Re: 225 Industrial Way, Portland, Maine

HWE P/N 10-039

At your request, I inspected the visible structure of the three mezzanines as built in your building at 225 Industrial Way, Portland, Maine. John provided access to the space.

NOTE: Mezzanines, 225 Industri
City of Portland Ordinances, base
Live load: 50 psf

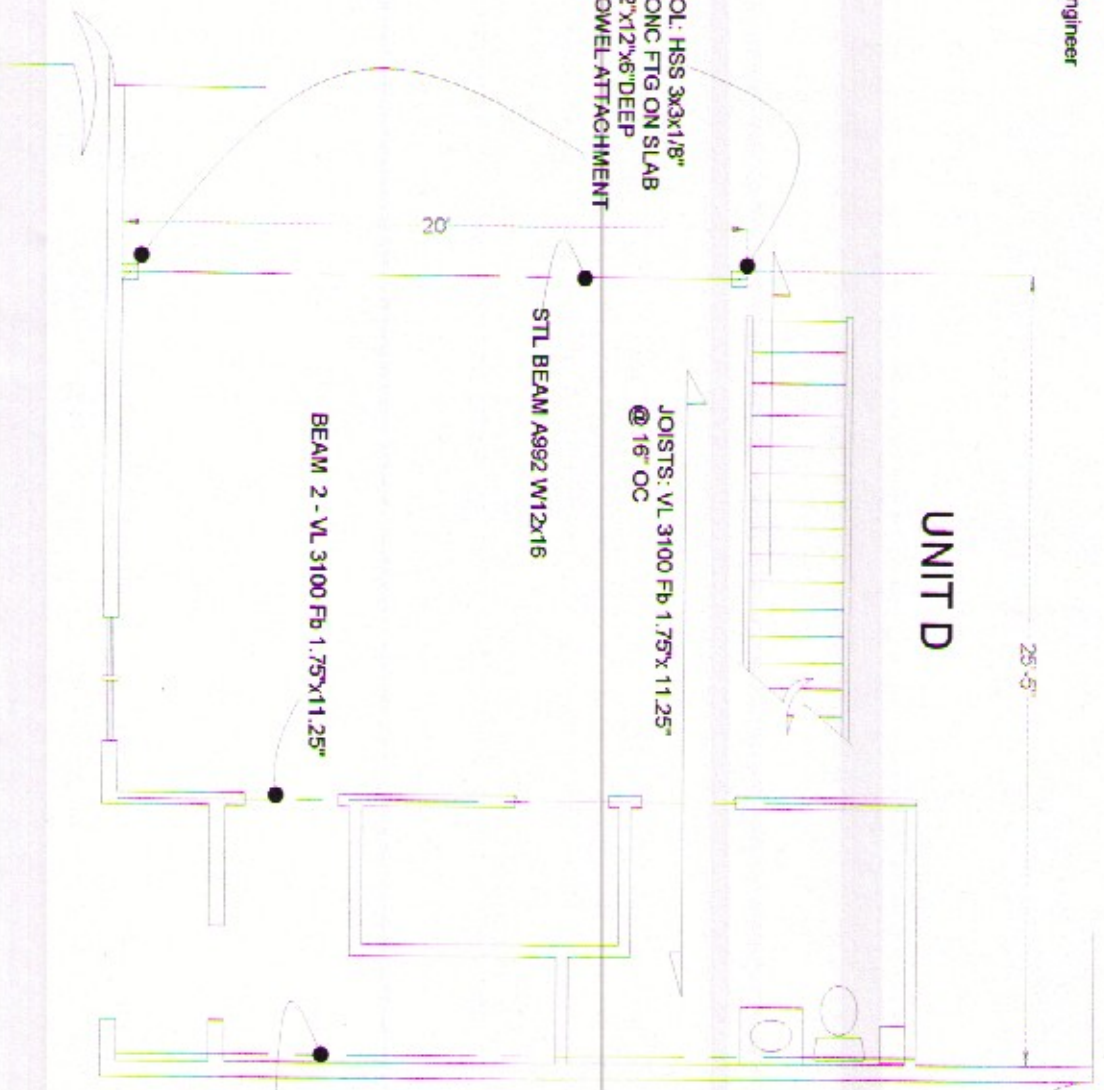
1. At the metal-stud bearing wall between the three sections of the building: Kamco studs are assumed to be equal to Dietrich 20 gauge 6" metal studs. Where framing is supported off the metal stud walls, the header is to be SPF#2 2x12 or better (*a 12" LVL was used*), attached to the studs with Dietrich S689 EasyClip™ S-Series™ Clip Angles or equal, see: (<http://www.dietrichindustries.com/products/>, p. 100-101, Floor Framing Connections), 9 screws to header, #10 metal screws, fill all holes to the metal stud.

2. Hanger for joists to header: Assume  $630(12/16) = 473$  plf header or 630#/stud @ 16" OC. At the steel-stud-framed walls between the three sections of the building, install Simpson LBV1.56/11.25 Hanger, or equal, full nailing, header to LVL joist. *Double joist hangers were used as needed.*

3. At steel beams: bolt 2x4 plate to top of steel beams to fasten a rim joist and LVL joists. *The joists are run over the steel beam so do not require a hanger.*

4. Columns: bolt 6x4x1/4" x 4" to bottom flange, 2 – 3/8" bolts, 4 – wood screws into column. One angle per column. *The bolting detail has the bolt welded to the steel flange to make a flat connection from the steel tube column to the steel beam. This is an adequate attachment.*

5. Columns at slab, bolt 6x4x1/4" x 4" angle to floor, 1 - 1/2" expansion bolt, 4 - wood screws to column. *The columns are placed on a cast-in-place base on the slab; the base is anchored to the slab with 4 dowels and the column is anchored to the base with a welded plate and four bolts. This is an adequate support and attachment. There is one steel column in Mezzanine D which is bolted to the concrete frost wall. This is an adequate support and attachment.*
6. *The outside edge of the mezzanine at the exterior wall is supported by a 2x4 which is attached to the exterior siding panels with a metal screw. This is lightly loaded, and adequate support is provided.*
